Subject: Planning Response for 19/02691/F - Public Rights of Way

No objections to the proposed development.

**SITE LAYOUT PLAN**

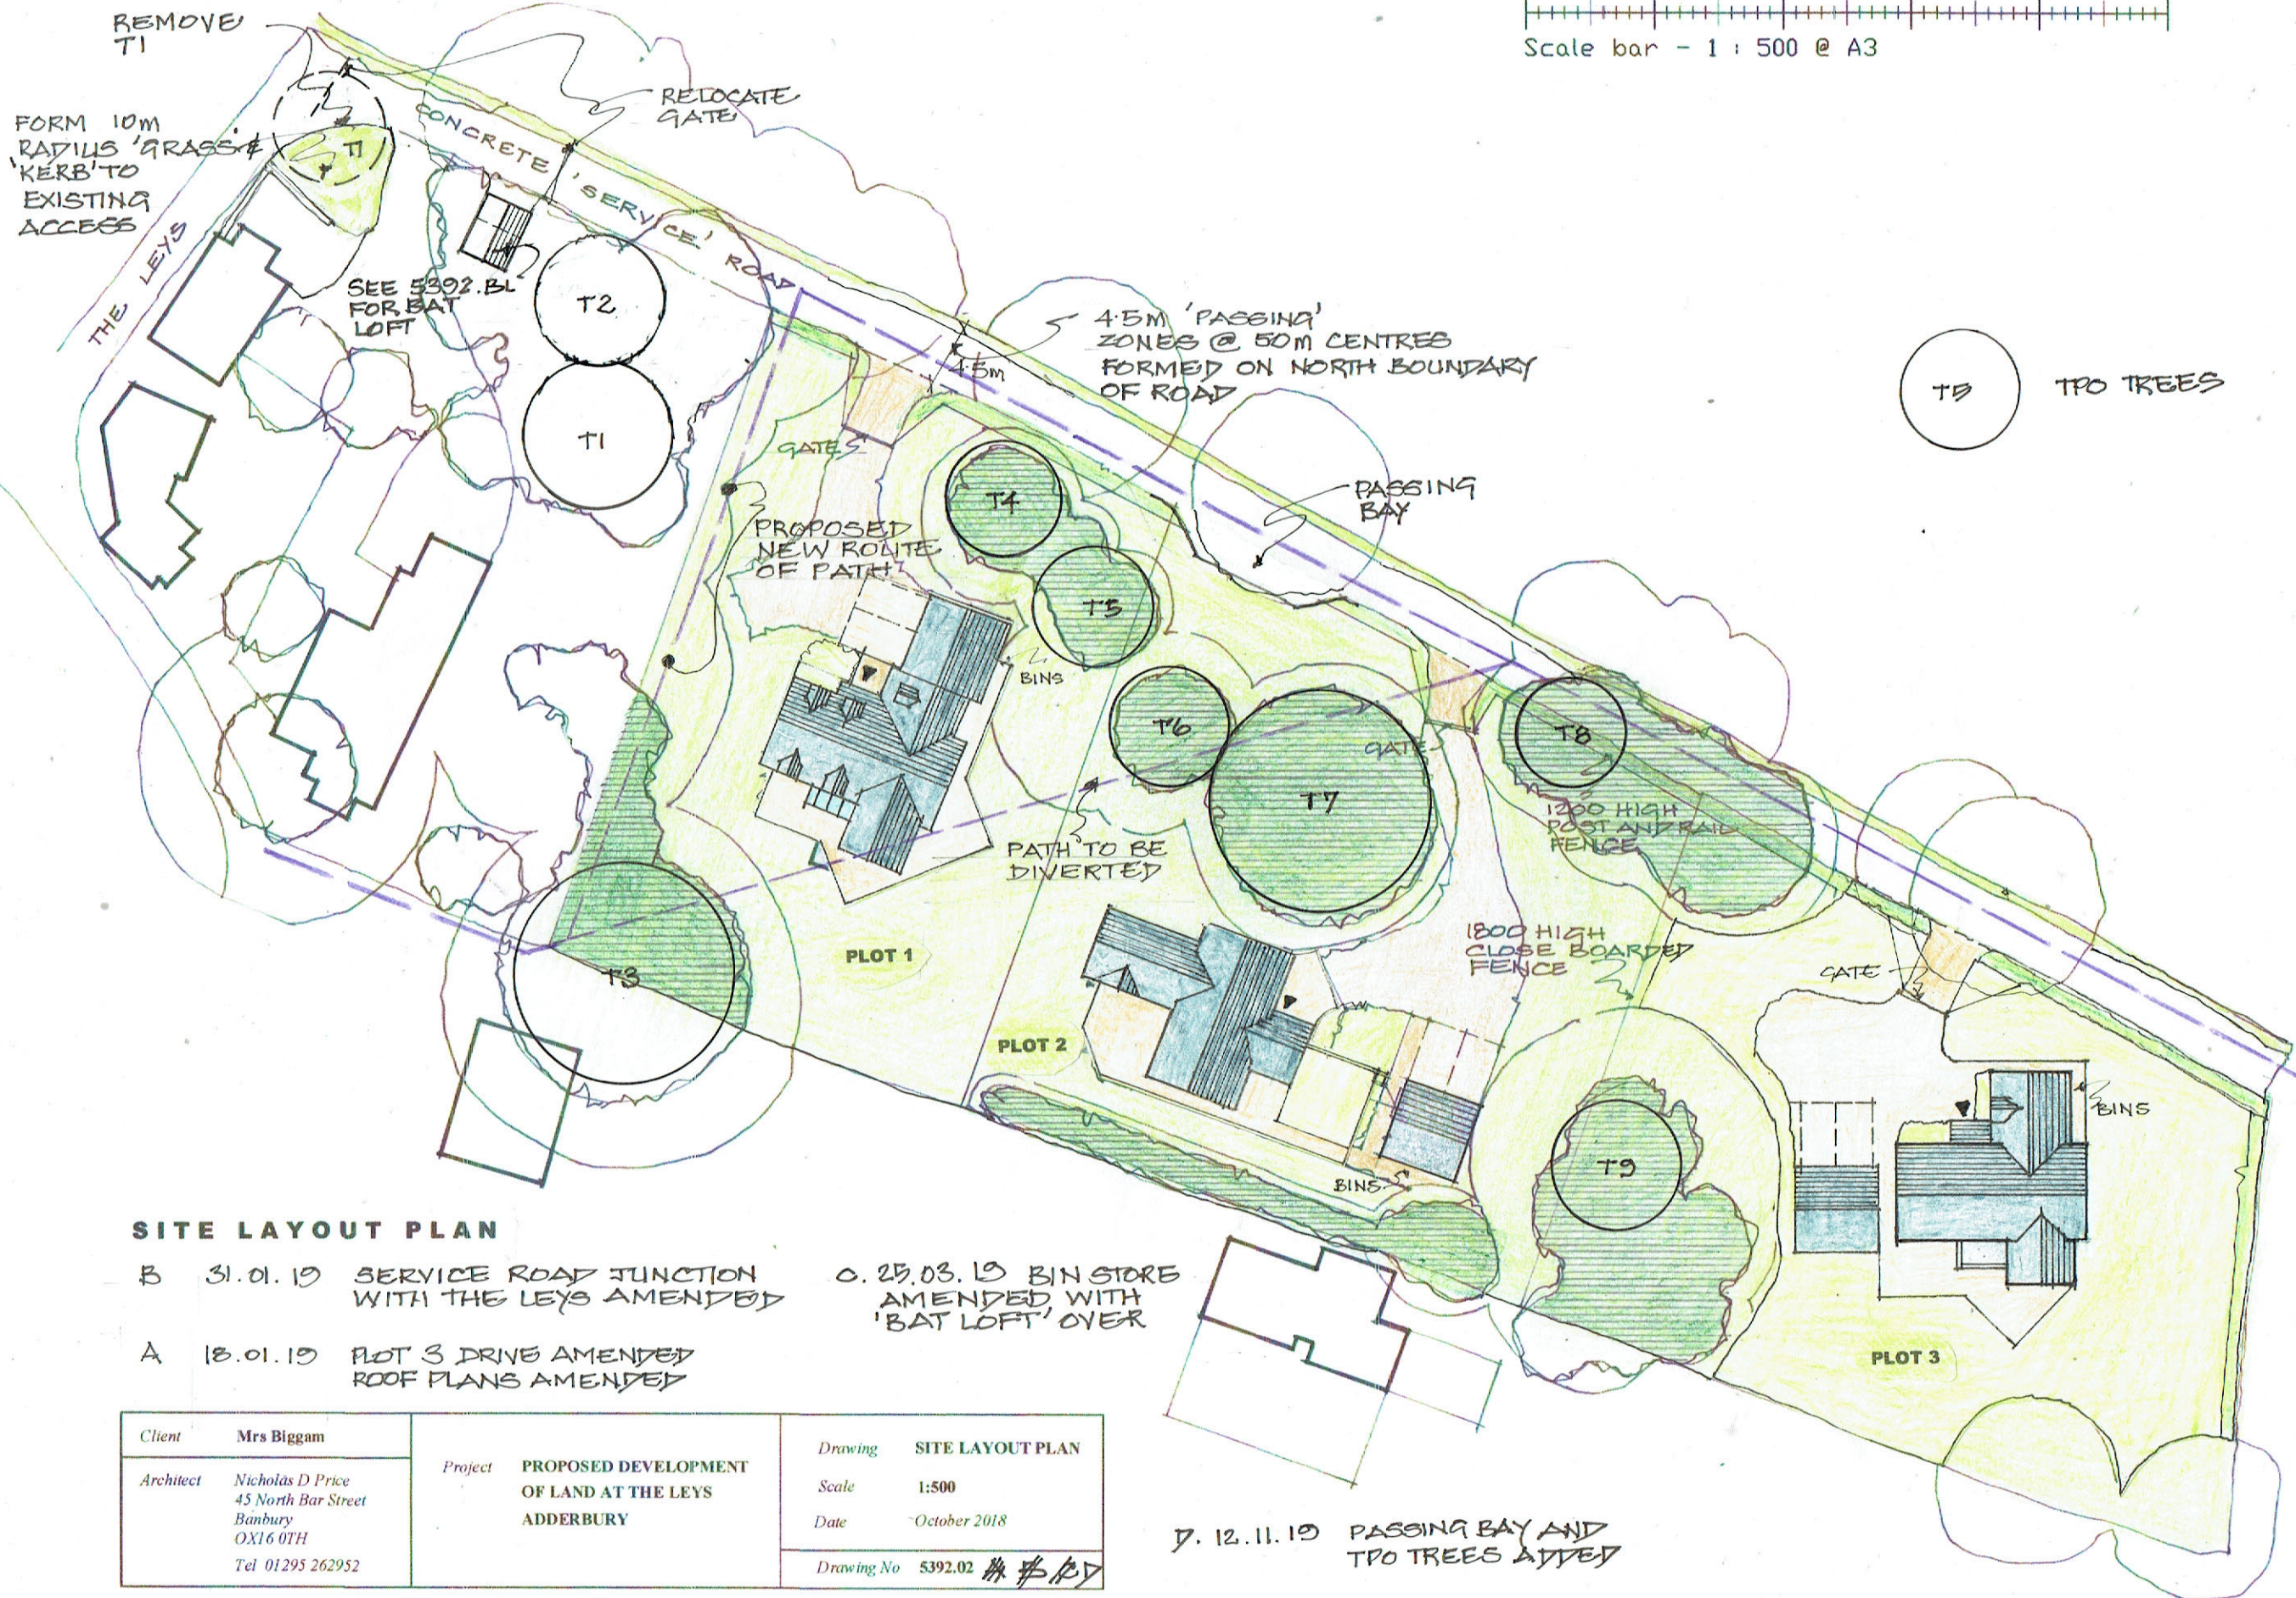
Applicant should note (as previously discussed) that the Public Footpath running through the site must be applied for and successfully confirmed before development work begins. This should be done via Cherwell District Council. Also as discussed the no stiles or gates should be added to the route. Fencing alongside the path should not be above head height to avoid creating an enclosed, dark and narrow route. The applicant should provide at least 3m width on the new diverted route.
